RE: Gloria Short Plat (SP-10-00001)

The Kittitas County Community Development Services Department has determined that the Gloria Short Plat (SP-10-00001) is a complete application and hereby grants **conditional preliminary approval** subject to the following conditions:

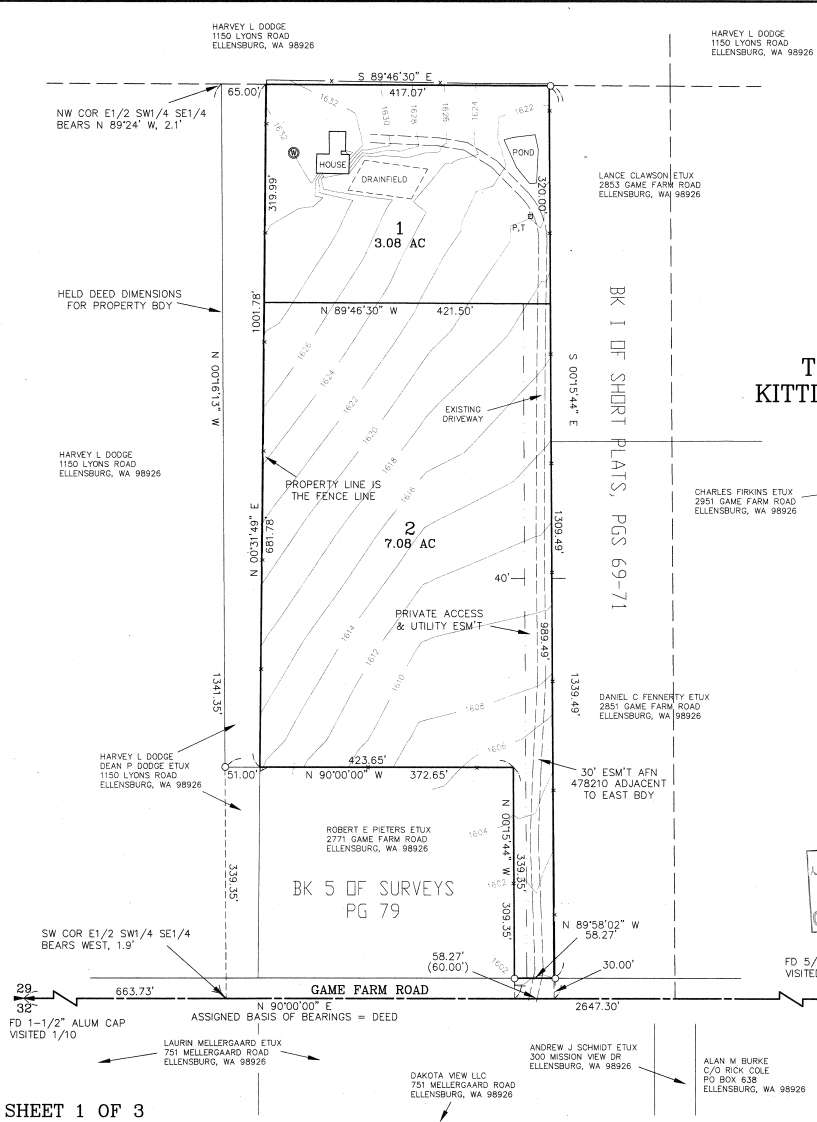
5. Lot 1 of the Gloria short plat has a PUBHx wetland in the northeast corner of the property. The final mylars shall reflect the location of this wetland and a statement on the plat shall read as follows: "Future development of lots may require a study by a certified wetland biologist to determine wetland classification and for buffer requirements pursuant to KCC Critical Areas Code."
